**TOWER 2, LEVEL 23
DARLING PARK, 201 SUSSEX ST
SYDNEY NSW 2000**

SECTION 4.55(2) MODIFICATION 2 TO SSD 7037 | 75-85 HARRINGTON STREET, THE ROCKS | RESPONSE TO SUBMISSIONS

project code	sheet no.	revision
GA85H	DA-4100-1	A6

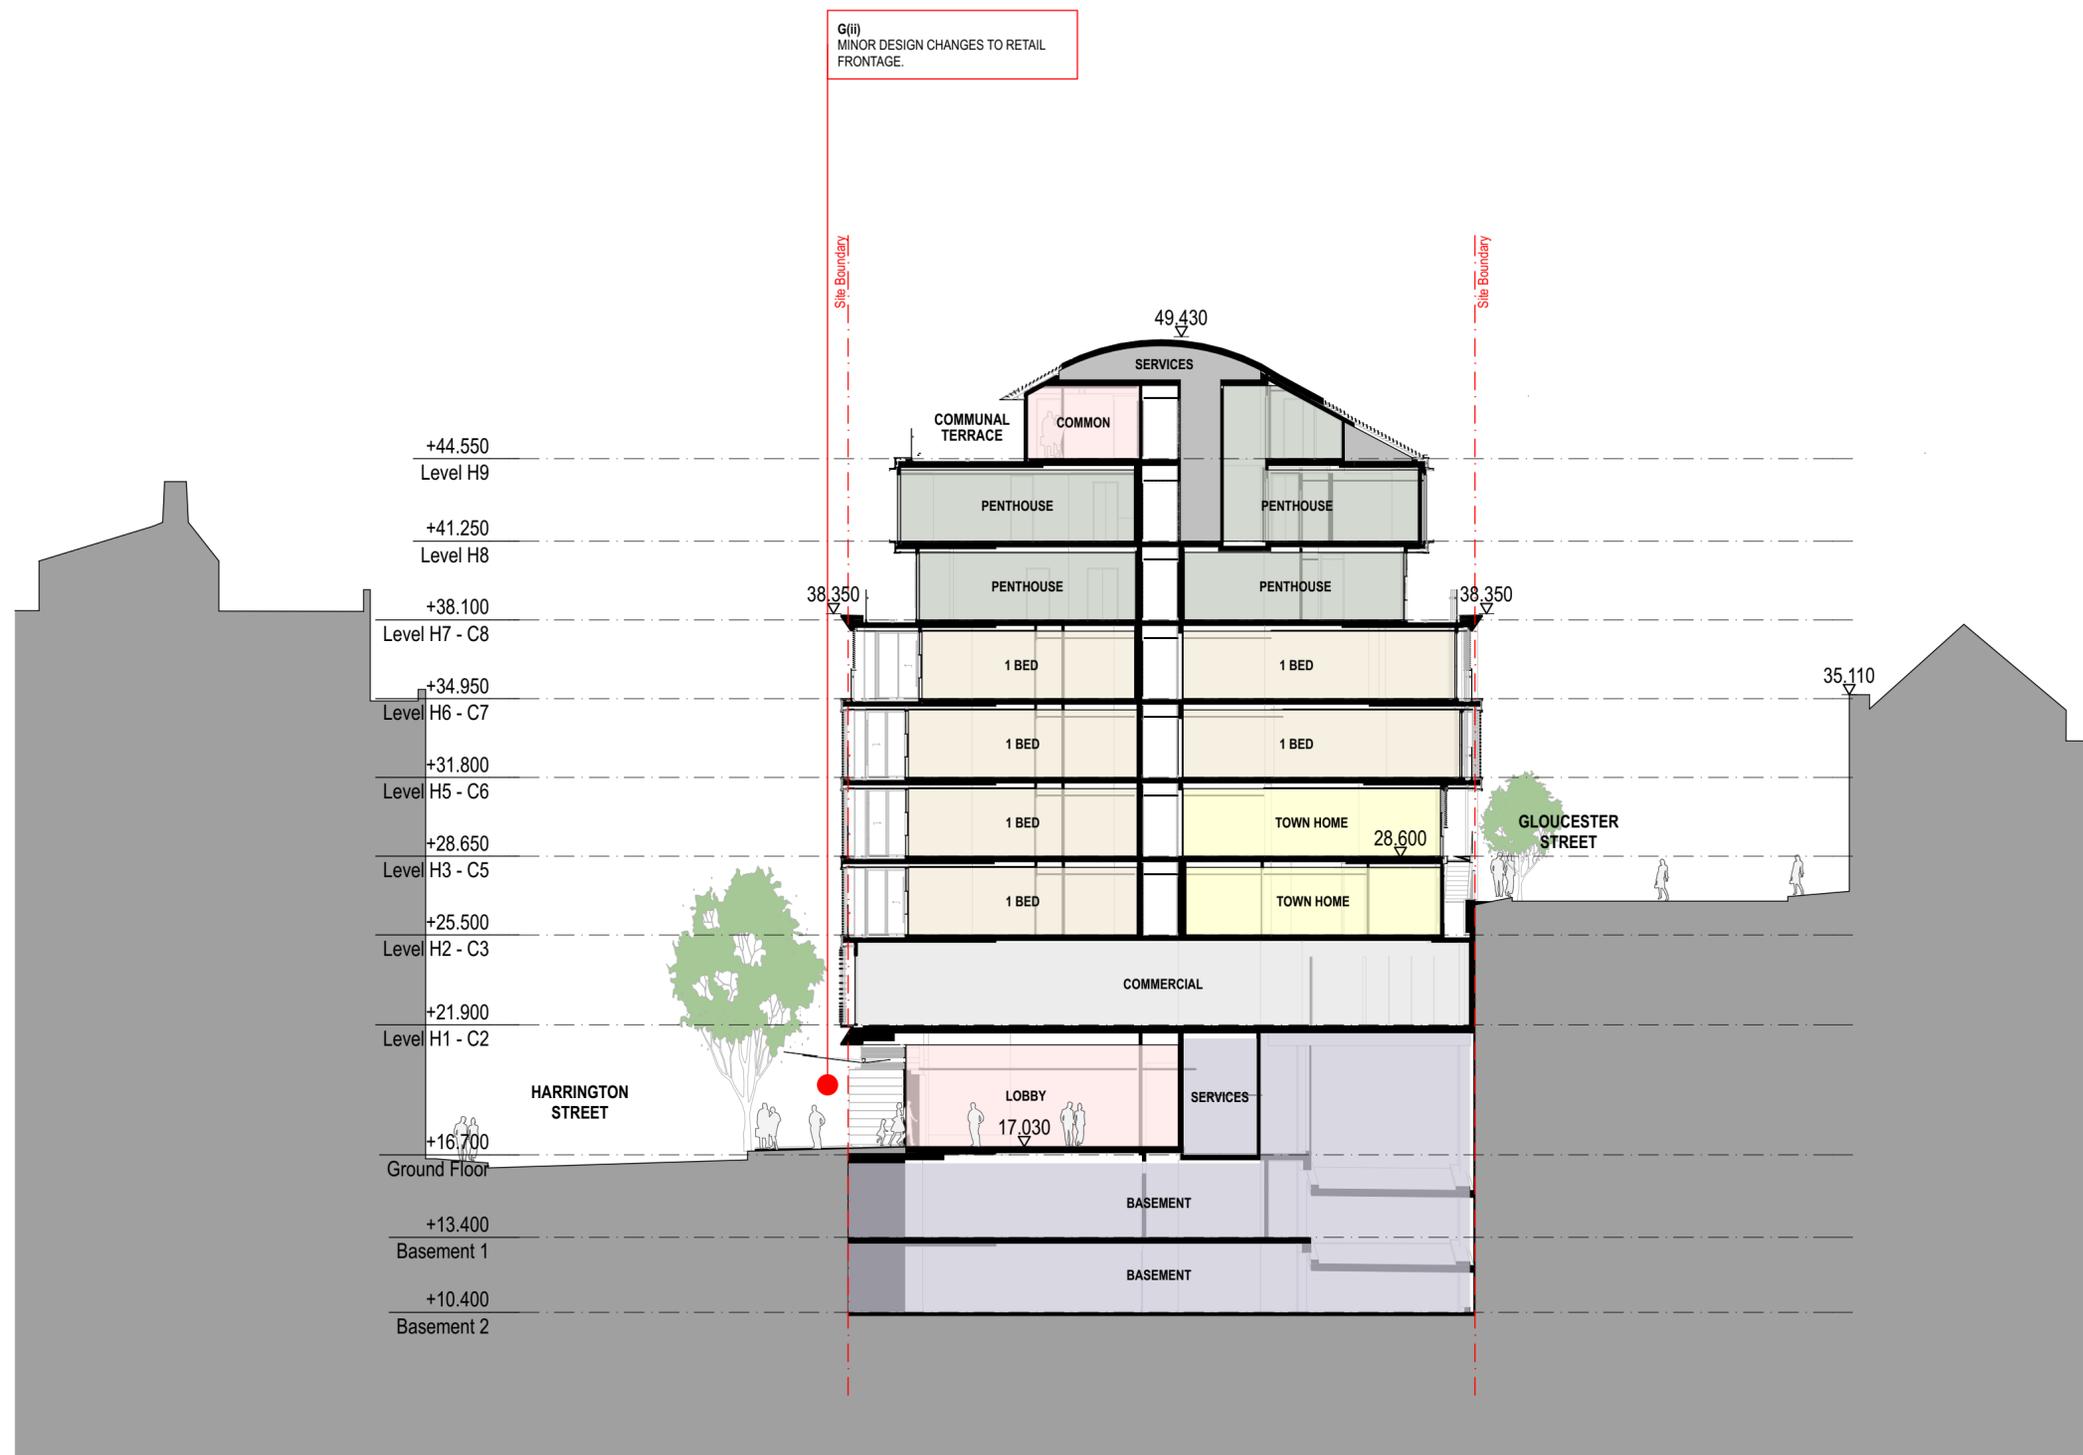
Issue	Response	Reference
<ul style="list-style-type: none"> Update all section drawings to reflect the amendments to the basement extent and internal changes 	Drawing DA-4100-1 is provided. All section drawings have been updated.	Drawing DA-4100-1 at Appendix B
<ul style="list-style-type: none"> Confirm no amendments are proposed to the roof level apart from those outlined in the planning statement and drawing amendments list 	Very minor setout amendments have been made to the private terraces on Level H9, however these are contained within the approved SCRA envelope.	-
Biodiversity		
<ul style="list-style-type: none"> Assessment requirements of Section 7.17 of the Biodiversity Conservation Act 2016 (BC Act). 	Refer to the Ecological Letter prepared by ELA at Appendix E which addressed the requirements of Section 7.17 of the BC Act. The letter confirms the modification “ <i>will not increase the impact on biodiversity values</i> ”.	Appendix E
